DRB CASE TRACKING LOG

Application No.: 02DRB-00748 (P&F)

Project # 1001957

Project Name: HOSHOR ADDITION

PLAT OF
 LOT 4-A & 6-A
 HOSHOR ADDITION
 SECTION 28, T. 10 N., R. 3 E., N.M.P.M.
 CITY OF ALBUQUERQUE
 BERNALILLO COUNTY, NEW MEXICO
 APRIL 2002

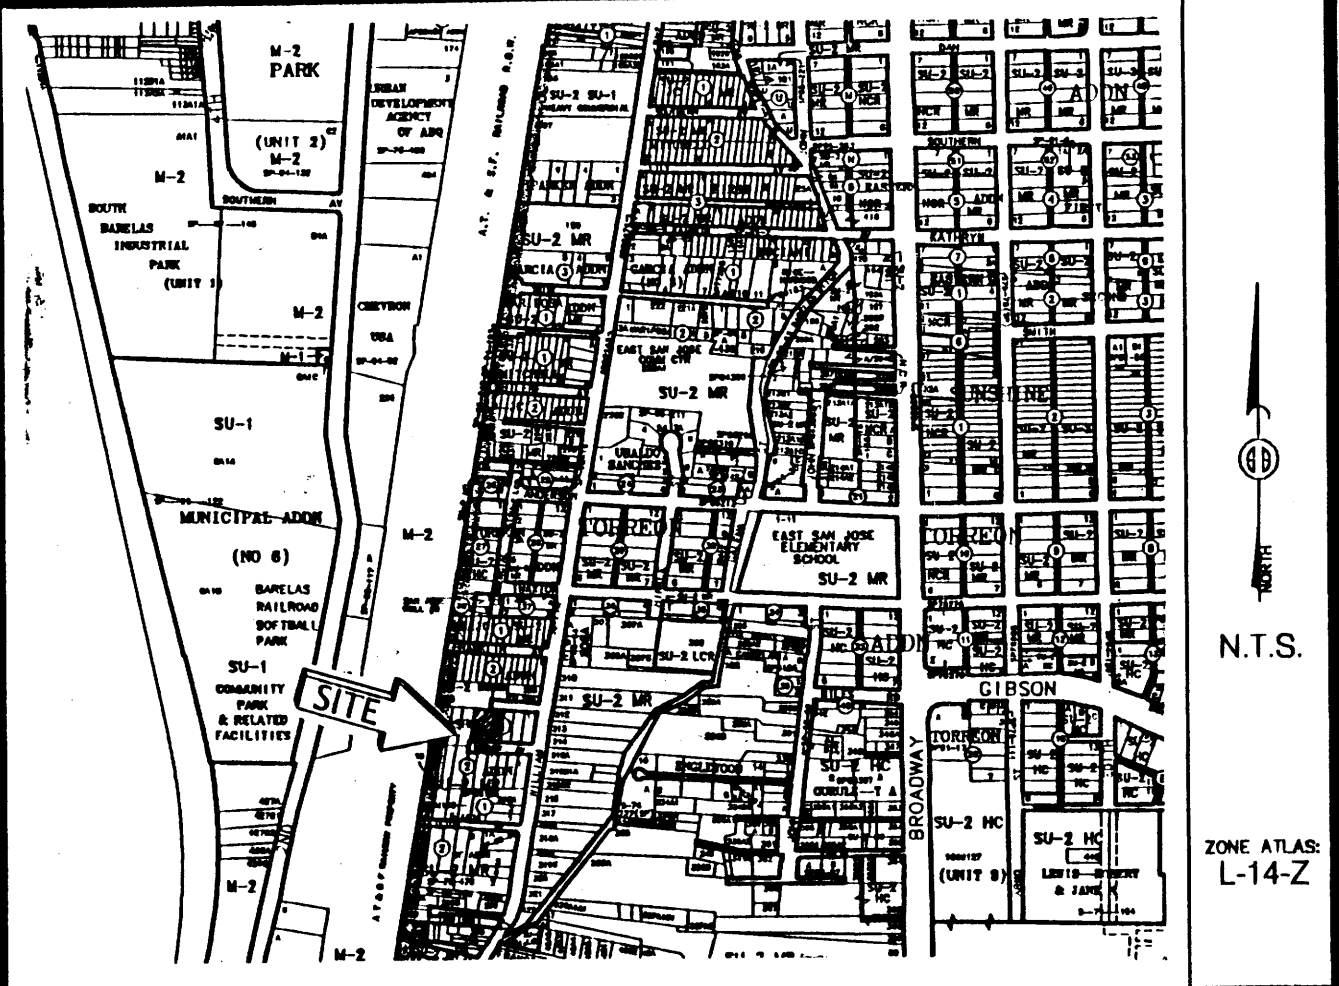
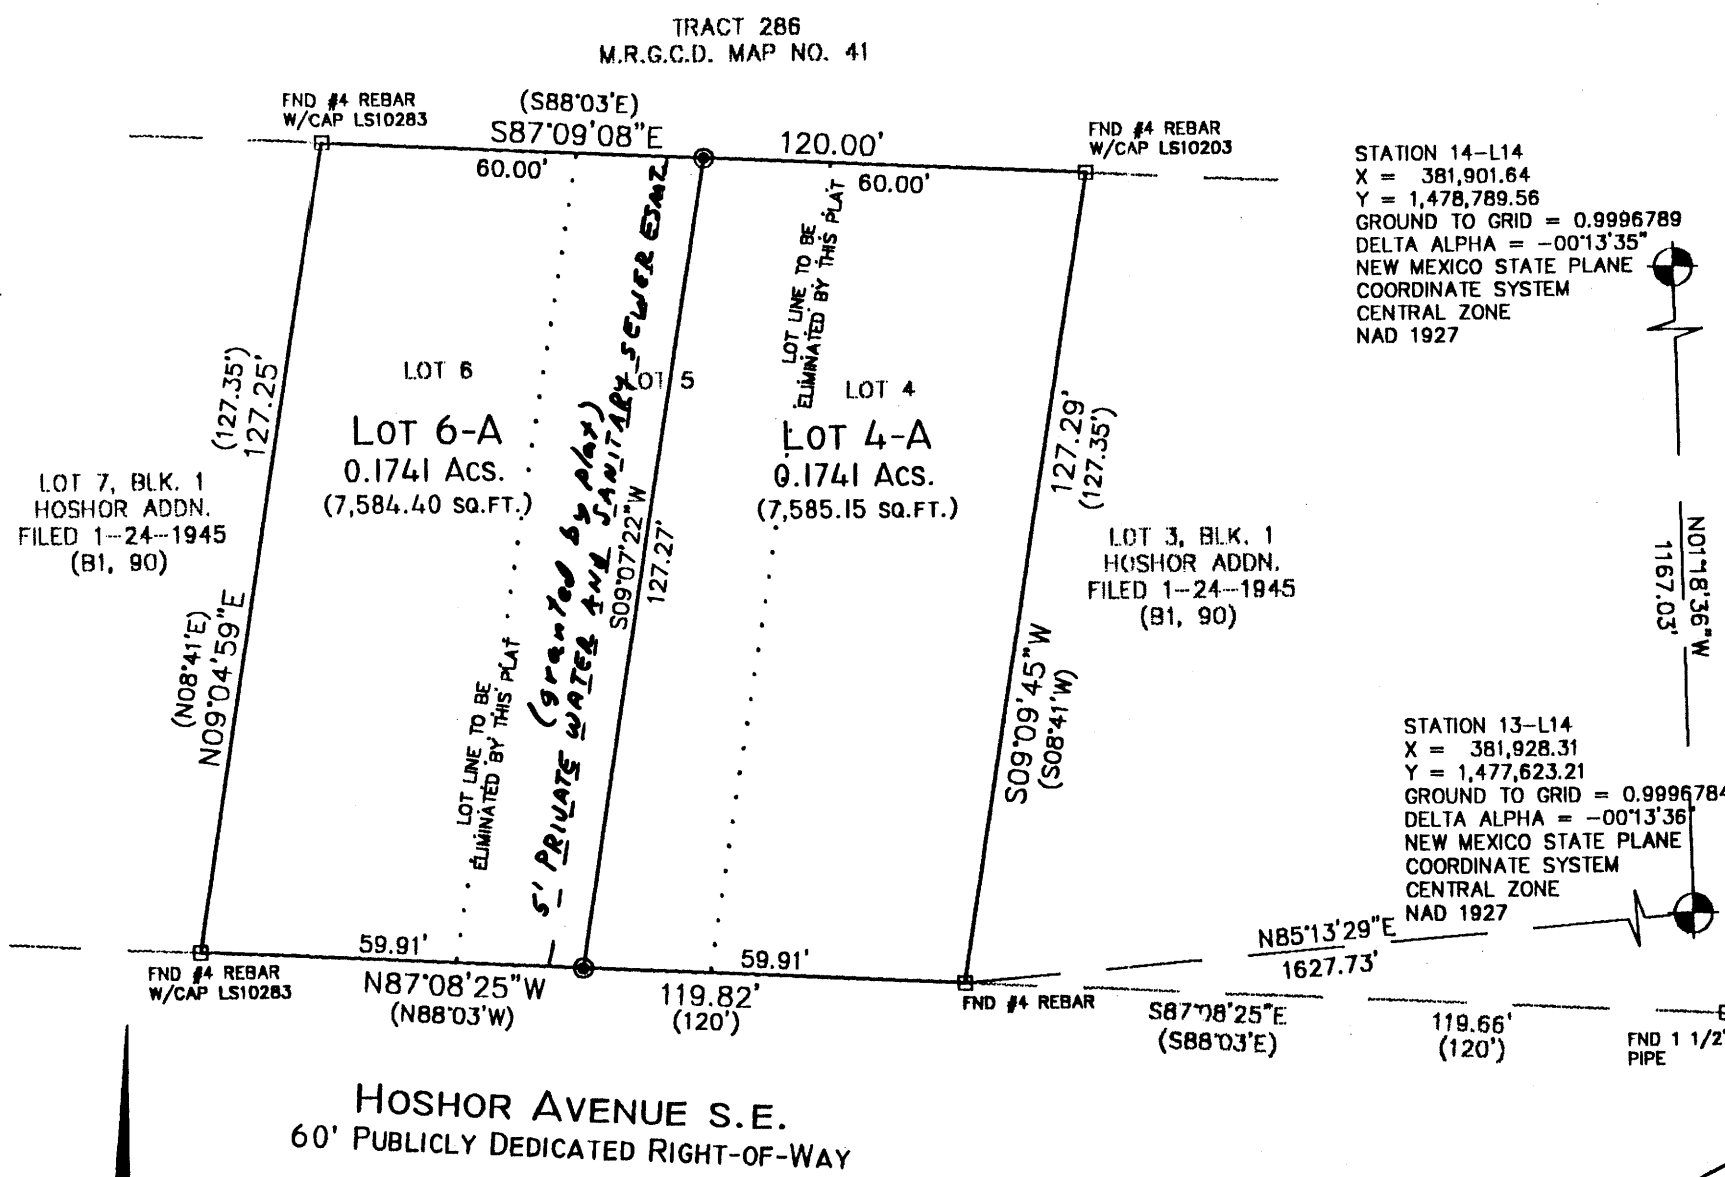
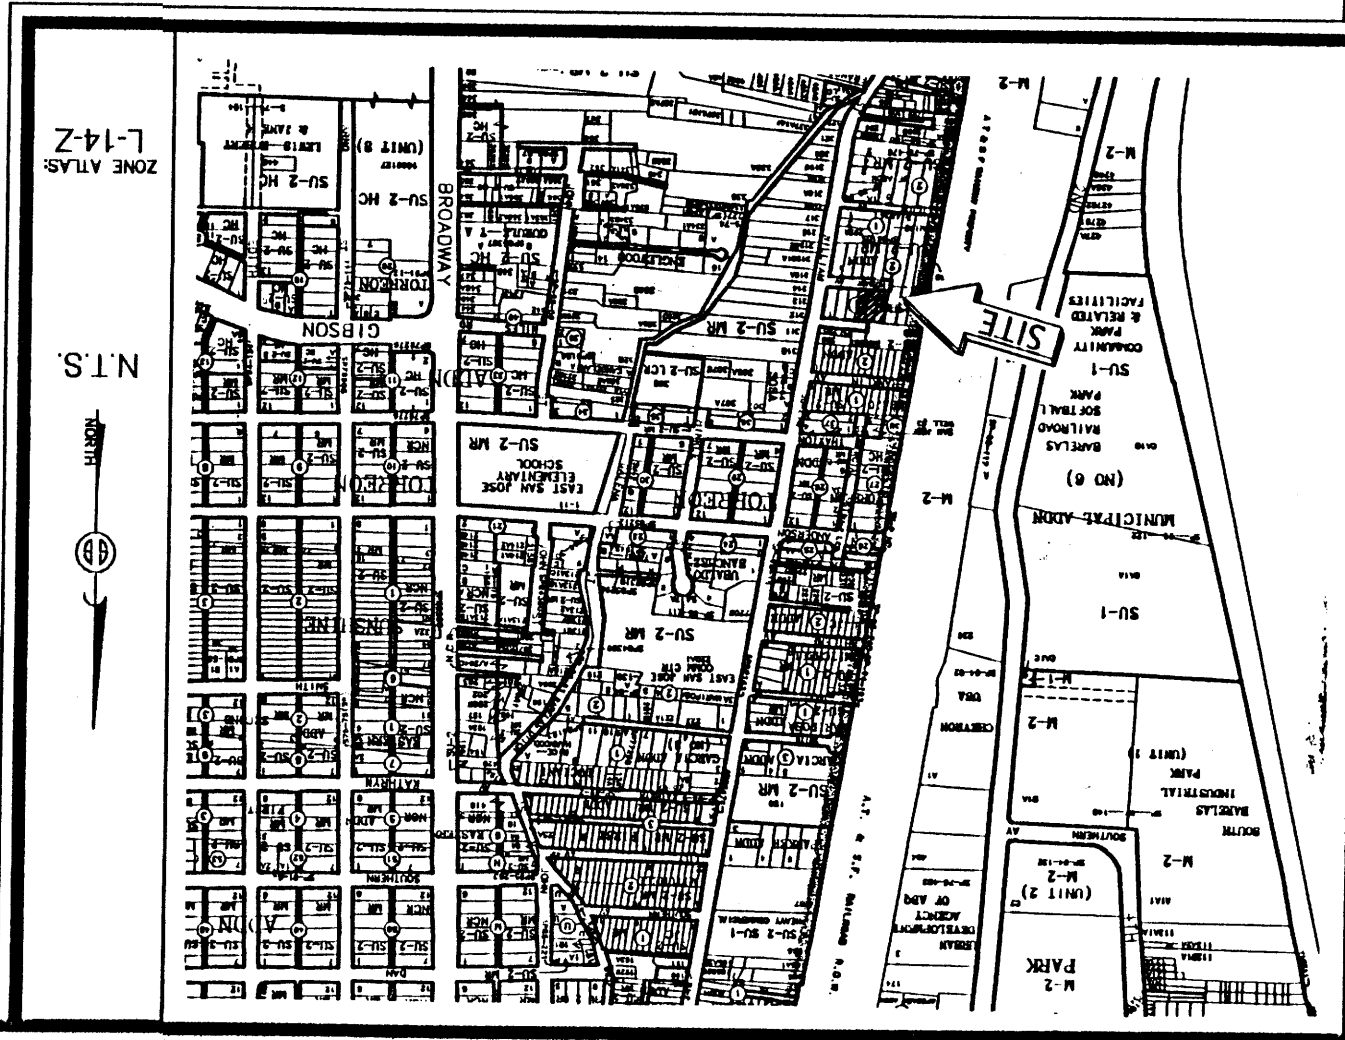
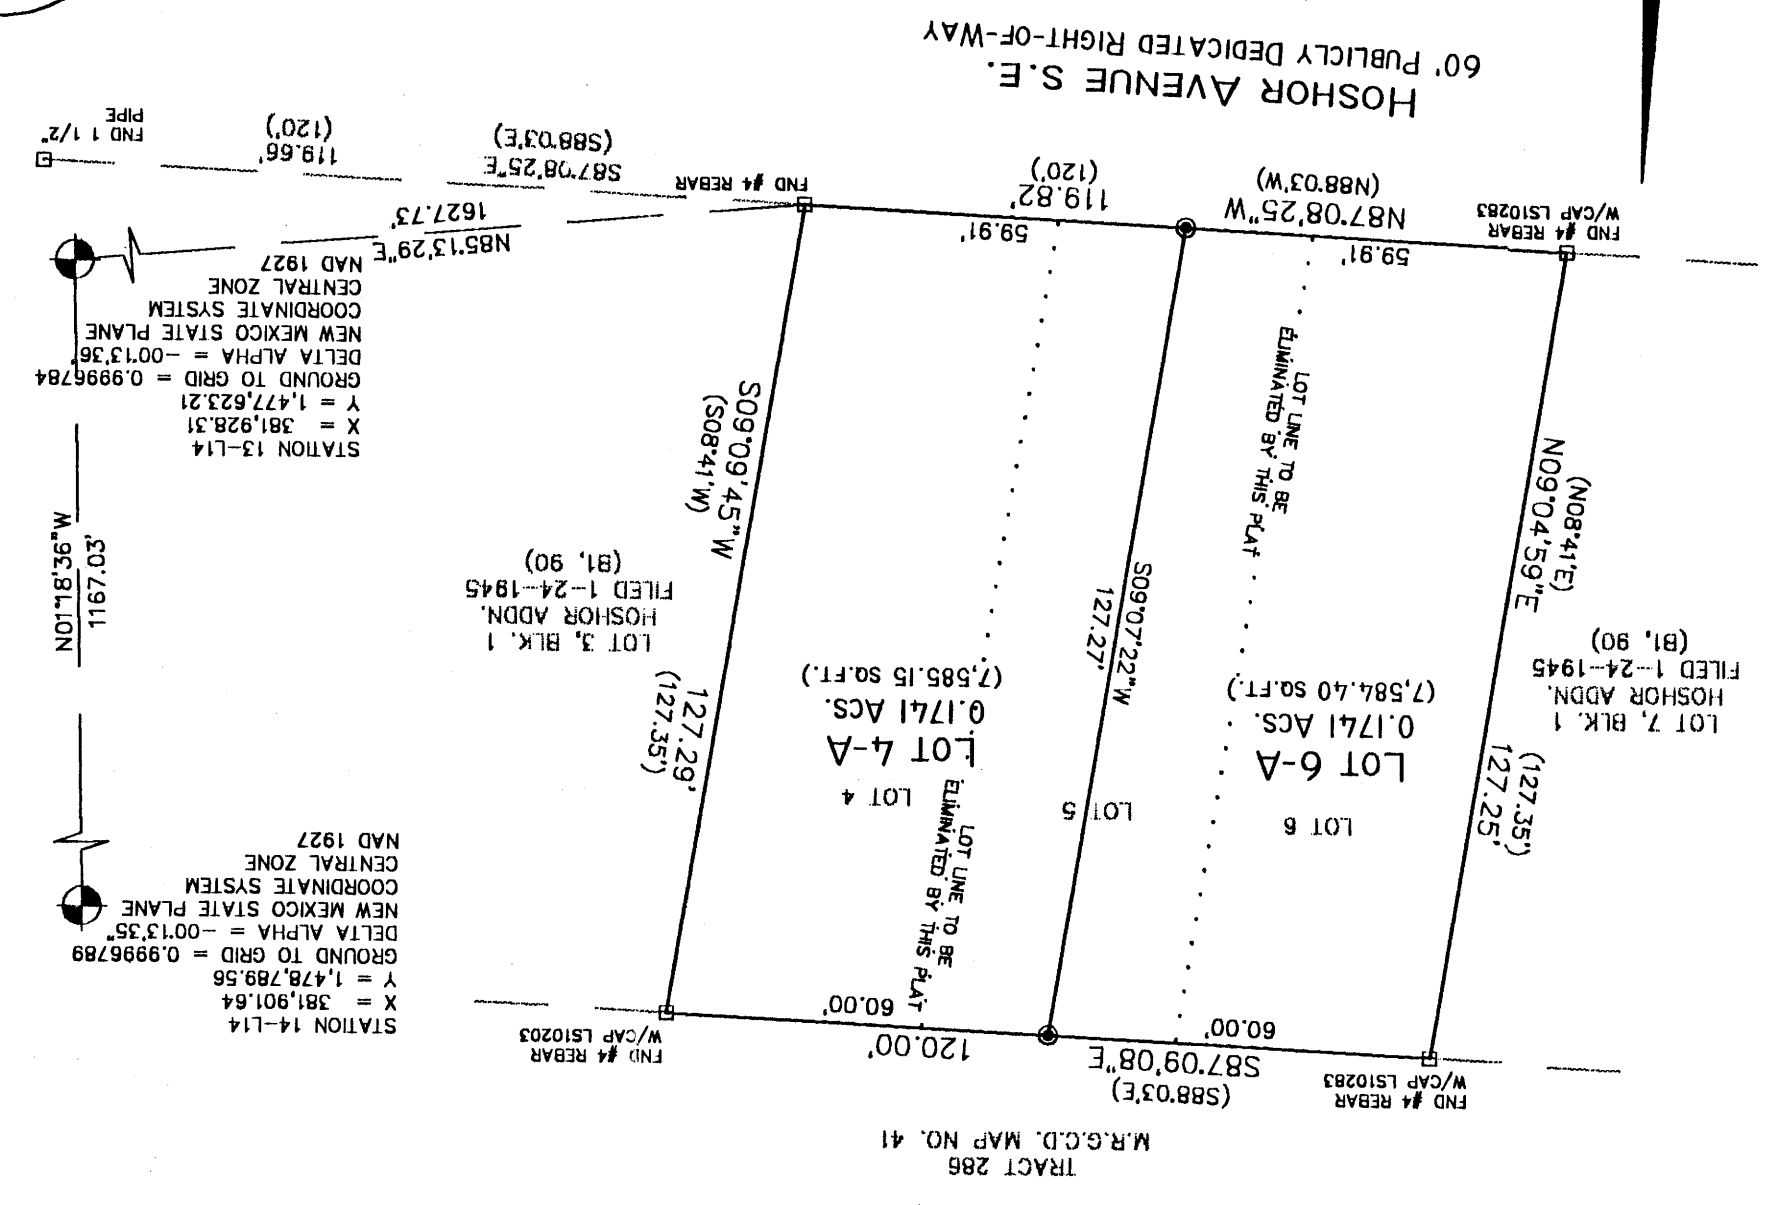
- TRANSPORTATION: _____
- UTILITIES: Locate existing water/sewer services from North lot & grant easement
- CITY ENGINEER / AMAFCA: _____
- PARKS / CIP: _____
- PLANNING (Last to sign): Setback variance
 - Planning must record this plat. Please submit the following items:
 - The original plat and a mylar copy for the County Clerk.
 - Tax certificate from the County Treasurer.
 - Recording fee (checks payable to the County Clerk). RECORDED DATE: _____
 - Tax printout from the County Assessor.
 - Include 3 copies of the approved site plan along with the originals.
 - County Treasurer's signature must be obtained prior to the recording of the plat with the County Clerk.
 - Property Management's signature must be obtained prior to Planning Department's signature.

The disclosure is unclear. For this file
it should say "local ground coordinates
rotated to grid."
Filename should be 1001957.dxf

2. The lot width and area requirements are in compliance with the zoning classification. However, it appears that setback requirements on proposed Lot 4-A will require a variance. Please contact the Office of the Zoning Hearing Examiner at 924-3938 for further information.

5. Please provide a digital dxf file showing right-of-way, parcel and easement lines shown on the final plat, in New Mexico State Plane Feet, NAD 1983. This information will be provided to AGIS.

The proposed replat of the above mentioned property requires no special exception from this office. The dwelling unit is non-conforming as to front and side setback. A property non-conforming as to setbacks, can remain because the proposed subdivision makes the property less non-conforming. Since the structure is not going to be altered the current non-conforming setbacks are allowed to remain.
